This two page GEC Plan is just for the Lift Station area. But my comments are mostly typical and can be applied to the other 3 sectors of this project.

D.R. HORTON - GRANDVIEW RESERVE
 SANITARY SEWER LIFT STATION
 DESIGN & PERMITTING SERVICES
 EL PASO COUNTY
 PEYTON, CO

CIVIL
 INITIAL-INTERIM EROSION CONTROL

SHEET
C110

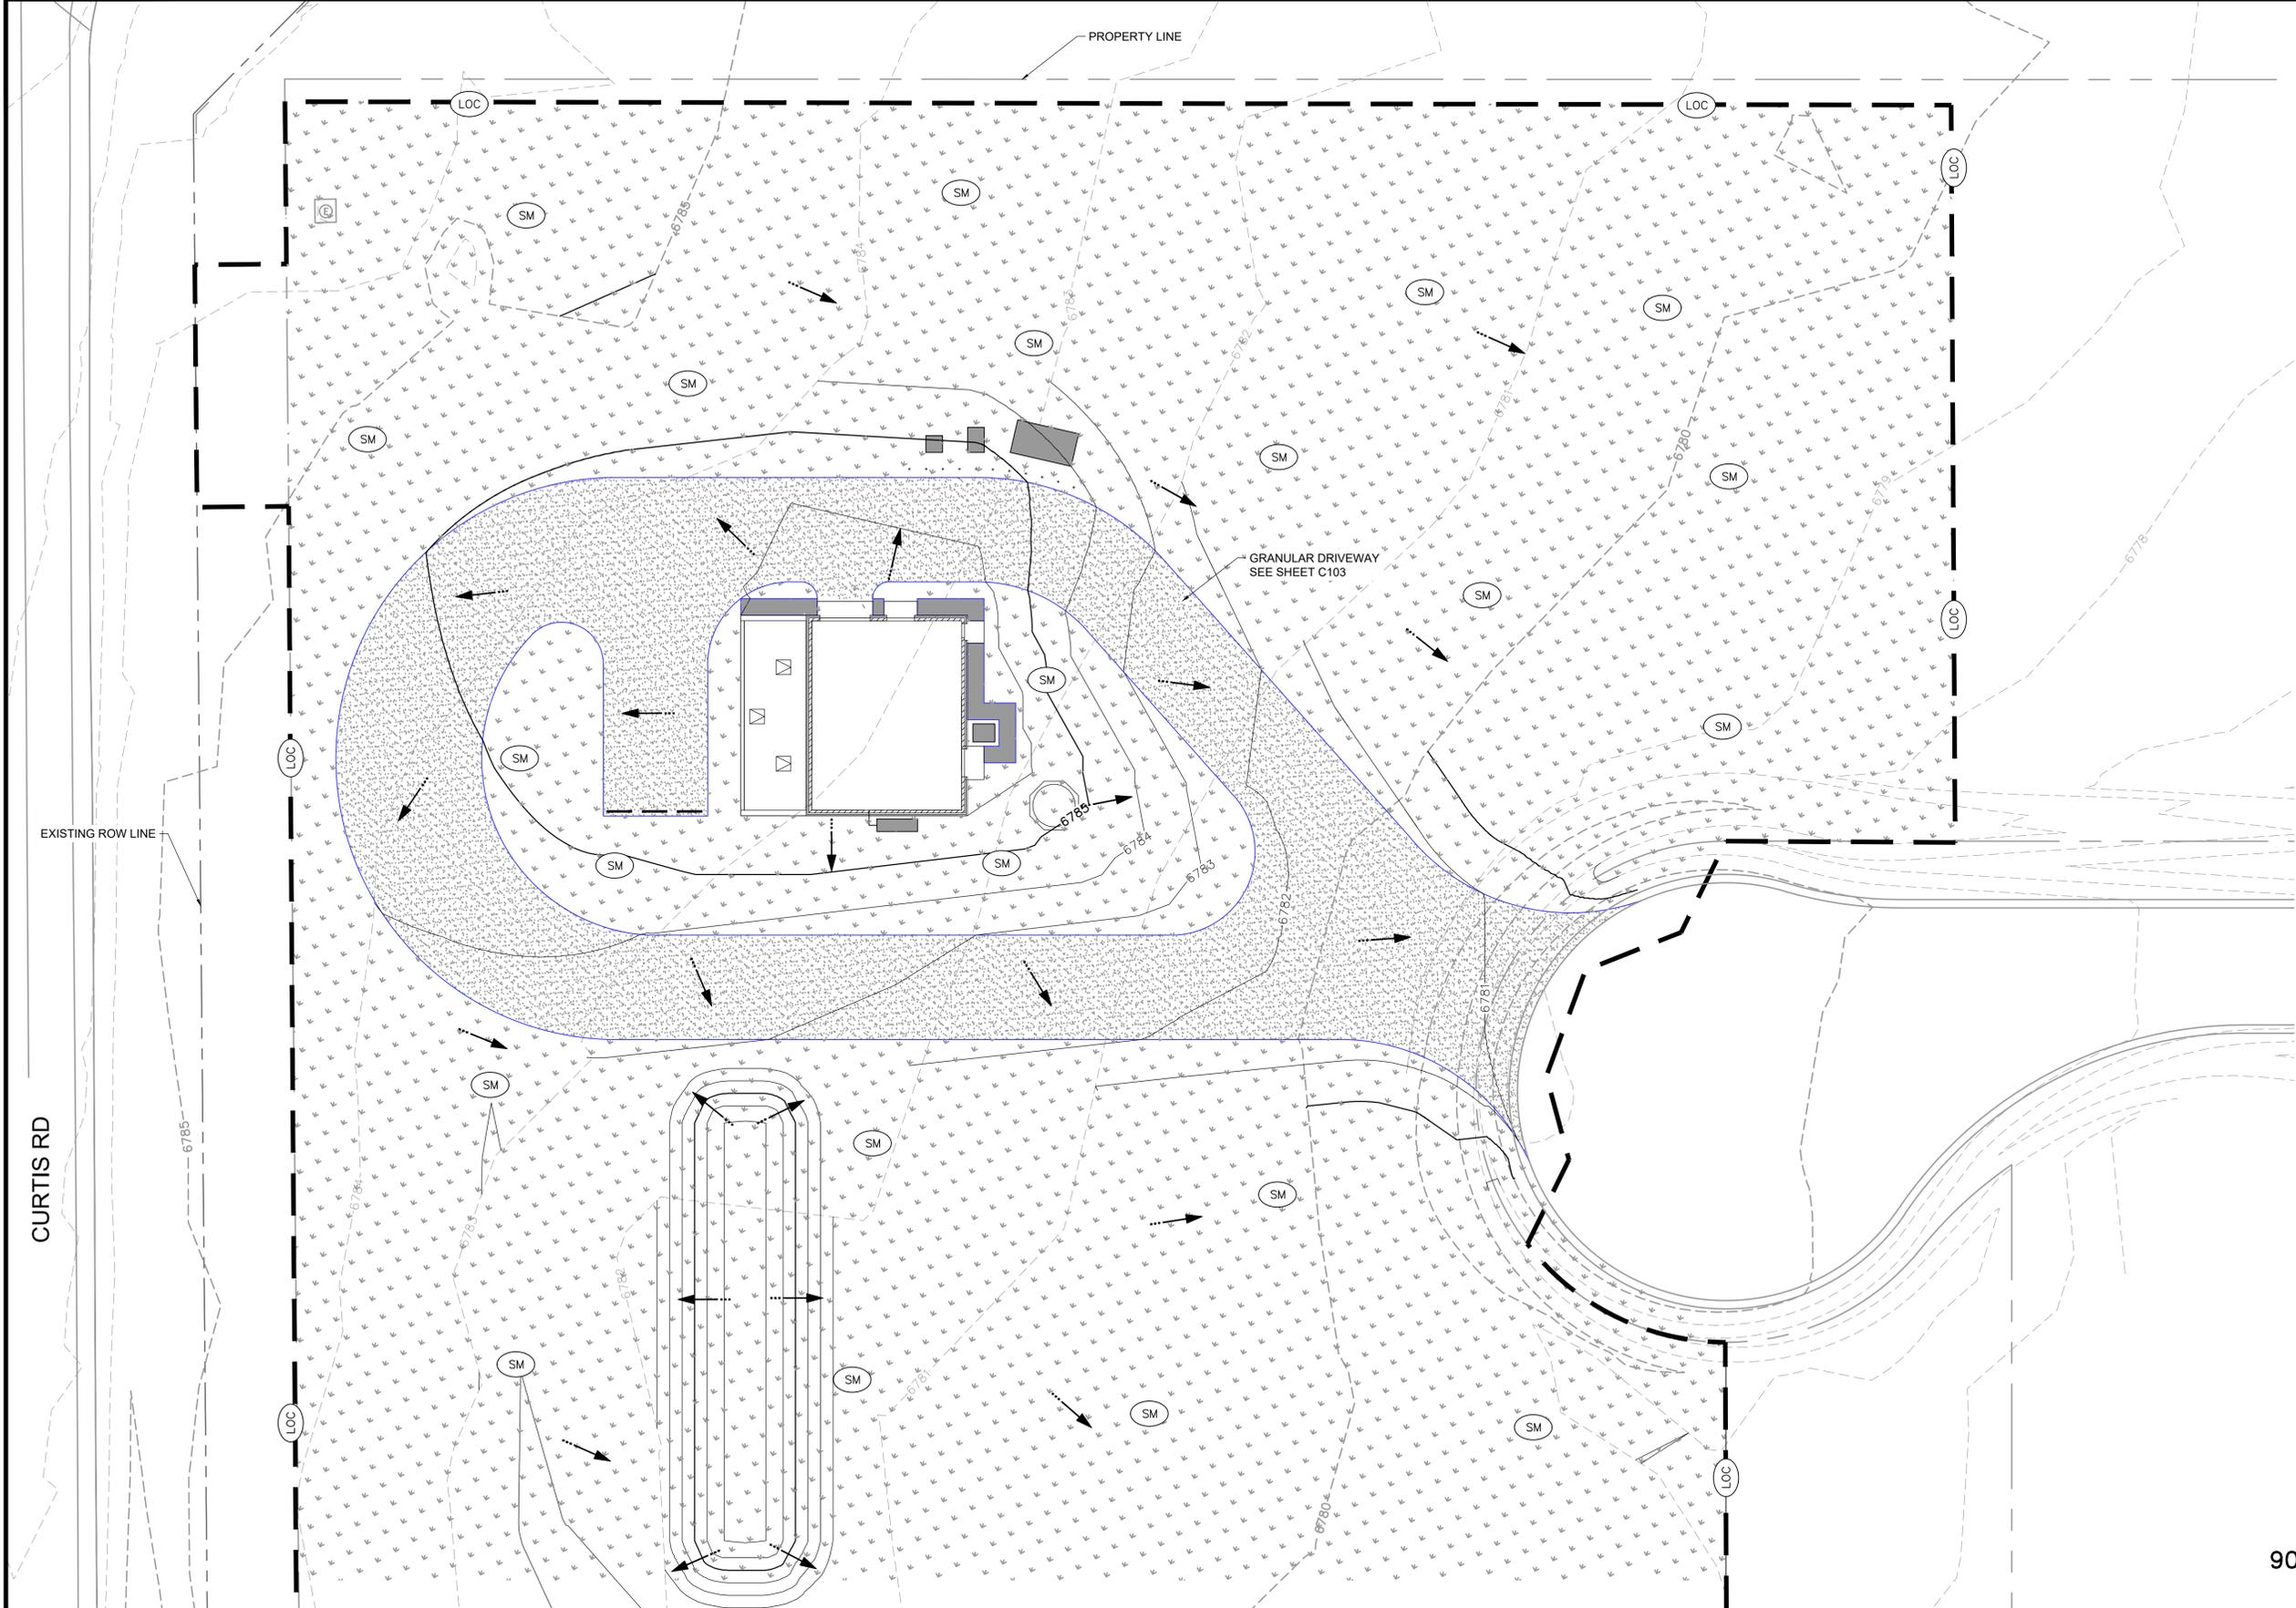
Include Title Sheet from SDP in this GEC Plan submittal. Because the GEC Plan must be submitted separately than a Site Development Plan (SDP) doc.
 GEC Checklist Item "b" - label adjacent parcels/lots.
 GEC Checklist Item "i" - Make a note about the condition/type of existing vegetation.
 GEC Checklist Item "p" - please delineate areas of cut/fill (so include Sheet C102 from SDP)

On the PBMP Applicability Form, it was stated that a WQ treatment facility is necessary for the lift station. But no PBMP is shown on these plans. Please show the PBMP and provide supporting details and calcs (calcs to be submitted in the form of a Drainage Letter with narrative).
 If a PBMP is required you will need some or all of these docs (depending on which type of PBMP):
 - Notice of Intent to Construct a Non-Jurisdictional Water Impoundment Structure (proof of submittal only)
 - O&M Manual
 - Private Detention Basin / Stormwater Quality BMP Maintenance Agreement [download from PCD website]
 - SDI Form or MHFD_Detention Calcs

Provide details for all temp BMPs that are shown on these GEC Plans

GEC Checklist Items H and M. If "limits of disturbance" and "construction boundary" are the same, change to "limits of construction/disturbance" or otherwise show as separate line types for each on the legend and figure.

Show proposed diversion ditches/swales to convey runoff to TSB.
 Provide details of temporary sediment basin including riser pipe diameter and perforation sizing, number of rows of holes, required volume, location of outlet pipe and spillway, and tributary area to the sediment basin. And provide contours for sediment basin.

Show southern limits of LOC. It goes off of the sheet here.

break SF within VTC

label street name
